Comments on the Applicant's D6 submissions

This document sets out the comments on the Applicant's Deadline 6 (D6) submissions by Cambridgeshire County Council (**CCC**), Huntingdonshire District Council (**HDC**) and South Cambridgeshire District Council (**SCDC**) (together, the **Councils**). The tables below set out the document in question that the Councils are commenting on, together with the relevant paragraph or reference number.

6.2 Environmental Master Plan [REP6-006]

Drawing Number: HE551495 - ACM - ELS - GEN_SW_Z_ZZ_DR-LV-0006
 Location: I Type: I Role: I Number: P02

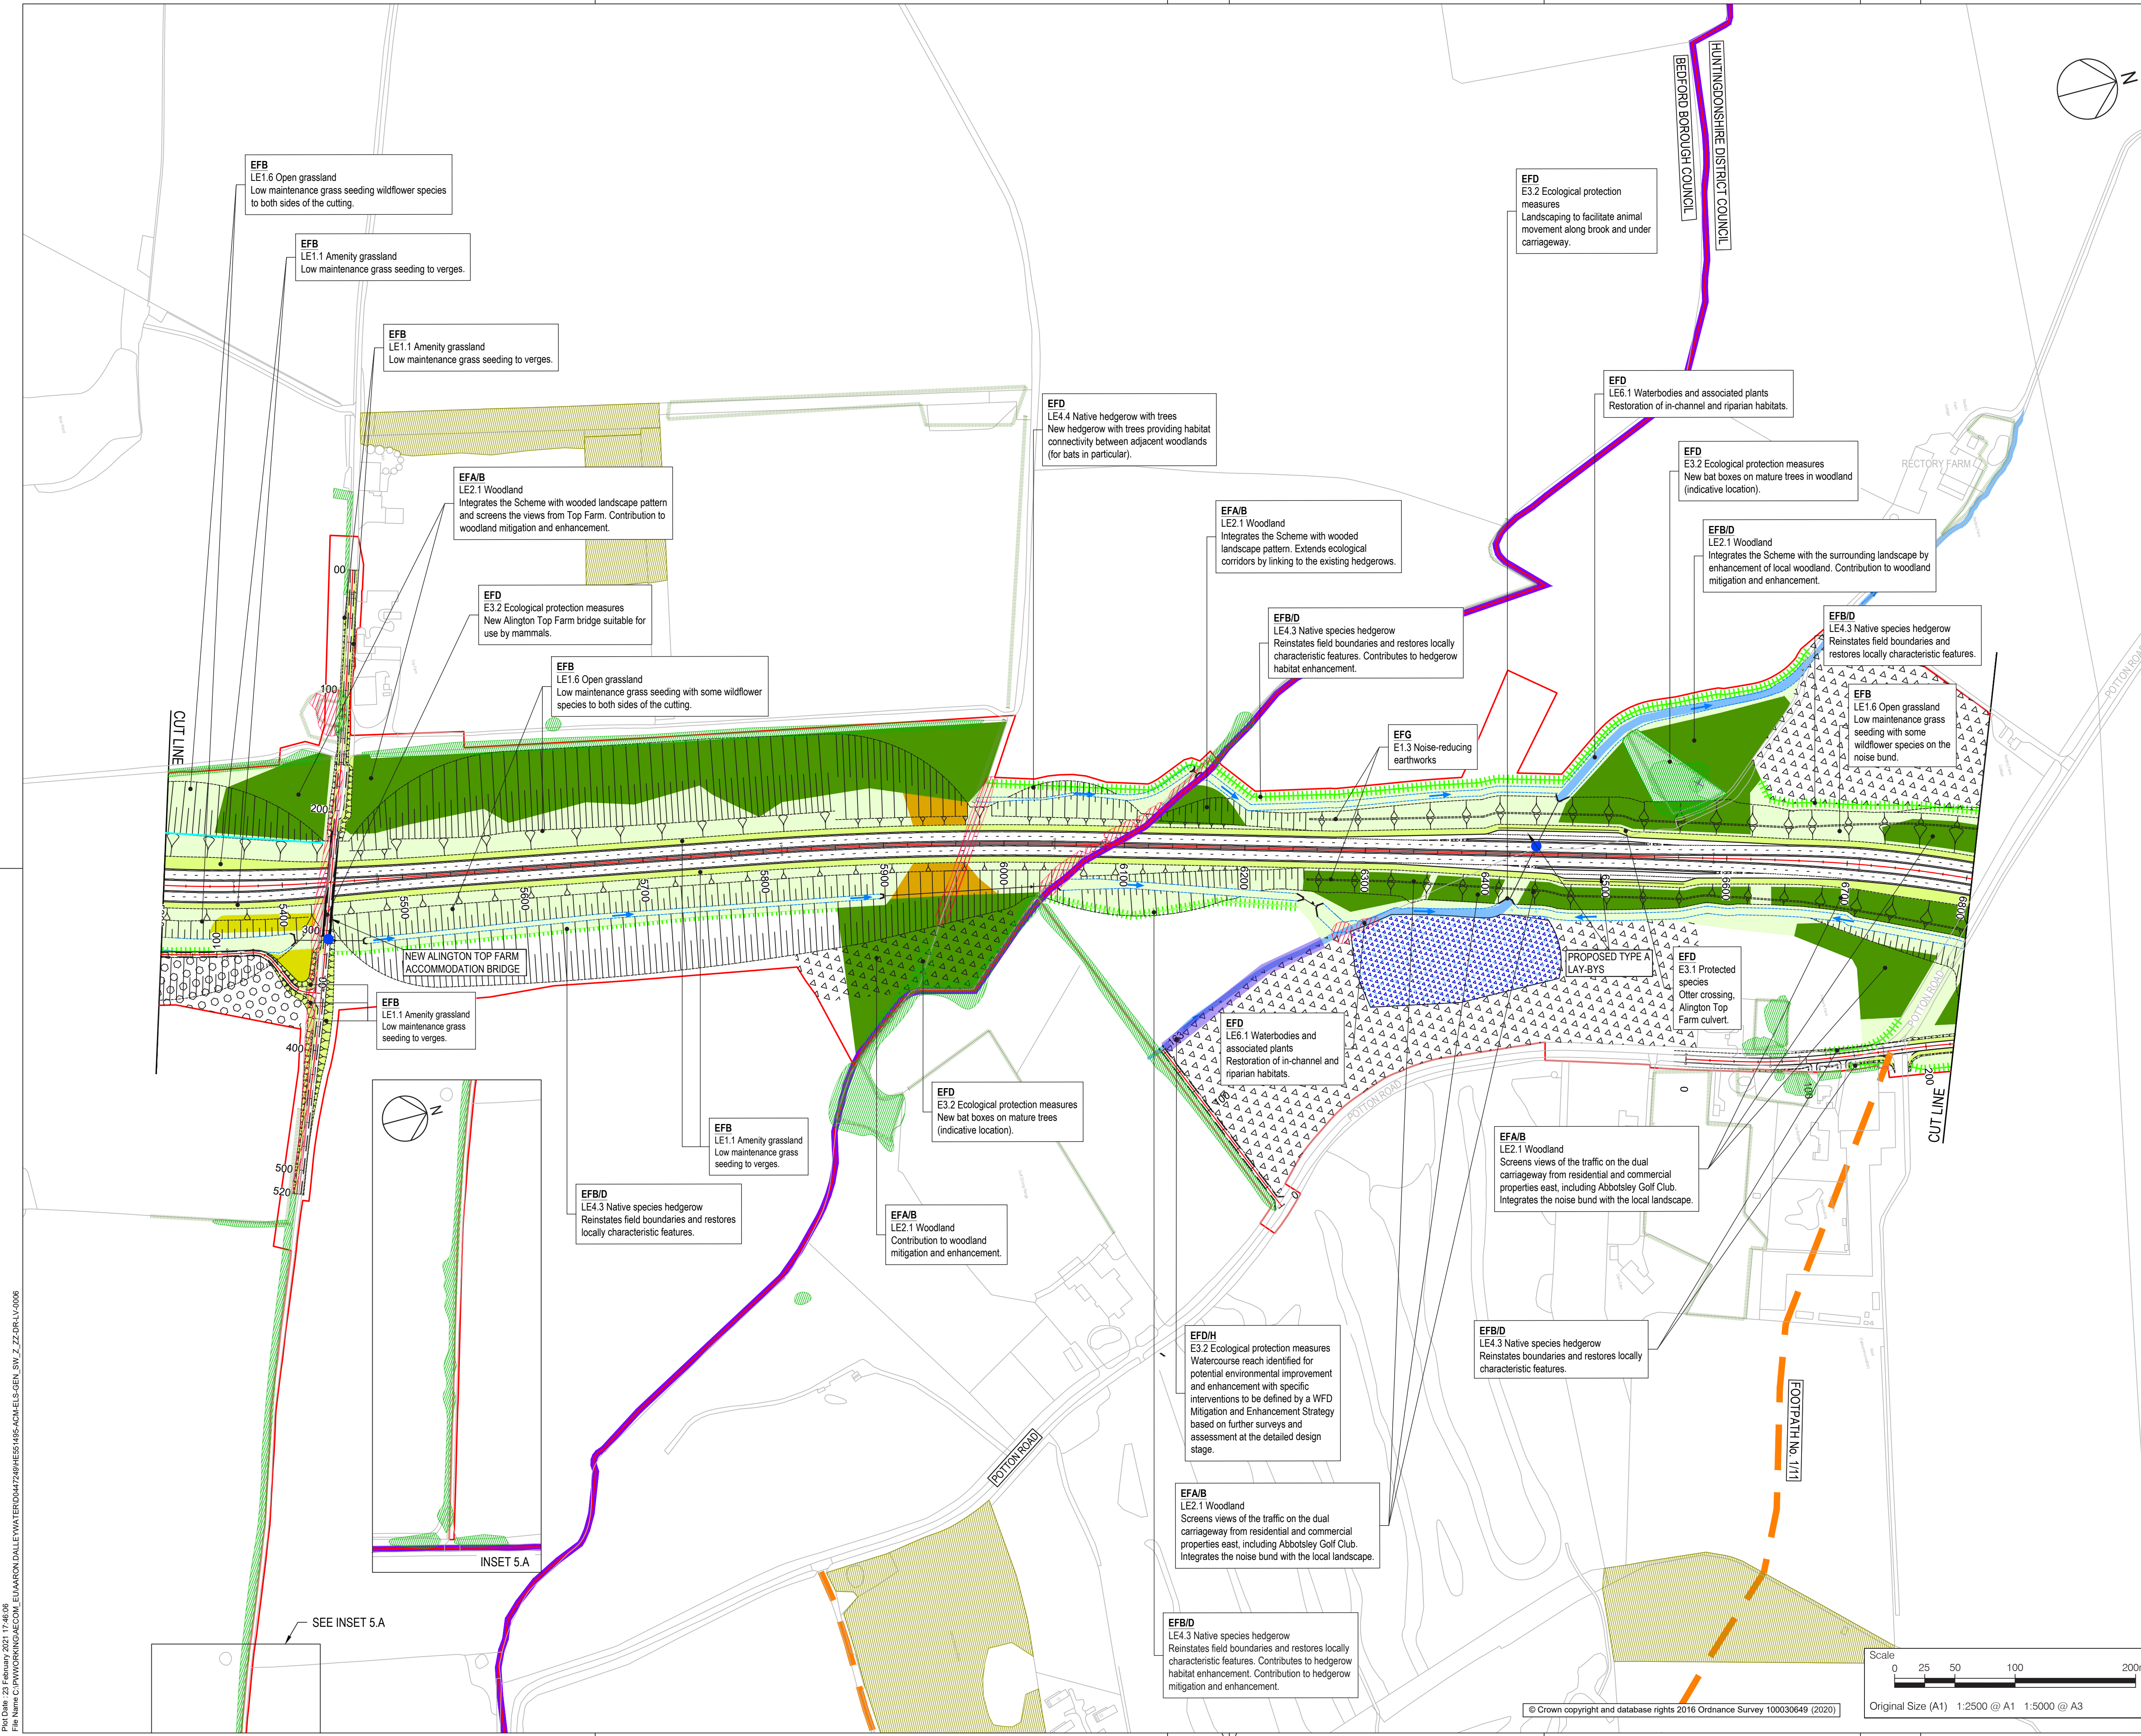
Topic	Paragraph Number	Councils' Comment
Great Crested Newt mitigation (pond)	Sheet 5	The Councils are concerned about the appropriateness of the proposed Great Crested Newt mitigation pond given it has been located within a field to be restored to arable and located away from known GCN populations. Further clarify is sought as to why this is suitable for GCN, rather than locating the pond within the affected GCN metapopulation boundary identified on the GCN Survey Update Tech Note [REP5-011] and therefore within surrounded by areas of optimal terrestrial habitat.
Great Crested Newt mitigation (pond)	Sheet 9	The Councils are concerned that a drainage attenuation pond is not suitable as a GCN pond. Its primary function as a drainage feature means it is likely to be dry and at risk of poor water quality. Further clarity is sought to demonstrate how this attenuation pond will be designed to support adequate water quality & quantity to support breeding GCN.
